Approval of details reserved by condition imposed under ref BN/84/20/PL relating to Condition No 7 - verification report demonstrating completion of works.

Land at Angels Nursery Yapton Road Barnham PO22 0AY

Arun District Council have decided to **REFUSE details reserved by condition for the following reasons:**

Section Through Proposed Capping Layer over Asbestos Affected Soil

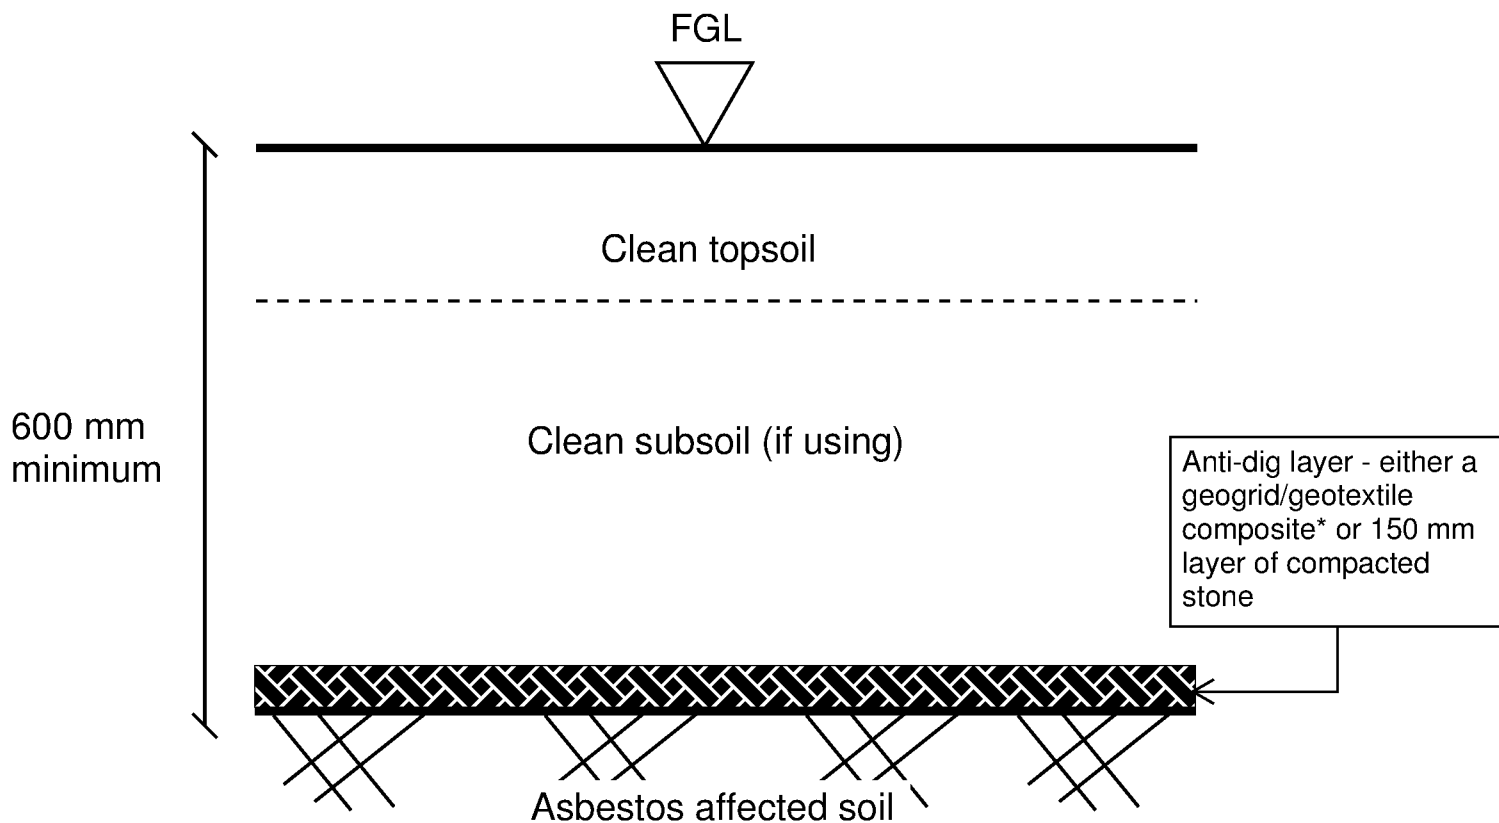
"Eastwood and Partners report (ref.: RAN/ME/44161-013, dated February 2022) which appears to relate to plots 13-15 and 39-39 has now been reviewed. It is understood that plot 13 has already been verified and is therefore not further considered. The submitted report contains no confirmation of the capping layer across plots 15 or 38, consequently these plots cannot be considered for discharge. In order for Environmental Health to consider plots 14 and 39 for discharge, please may the applicant provide the following information:

- Details of the geotextile membrane and confirmation that this extends across the entire garden
- Confirmation of the depth(s) of the soil samples.

Eastwood and Partners letter report (ref.: CAT/RAN/44161-007, dated September 2021) relates to plot 49 and has now been assessed. It is not possible for Environmental Health to consider this plot for discharge until the laboratory results have been returned. In the meantime, the sample 2 depth and location of the verification pit should be confirmed and details of the geotextile membrane provided.
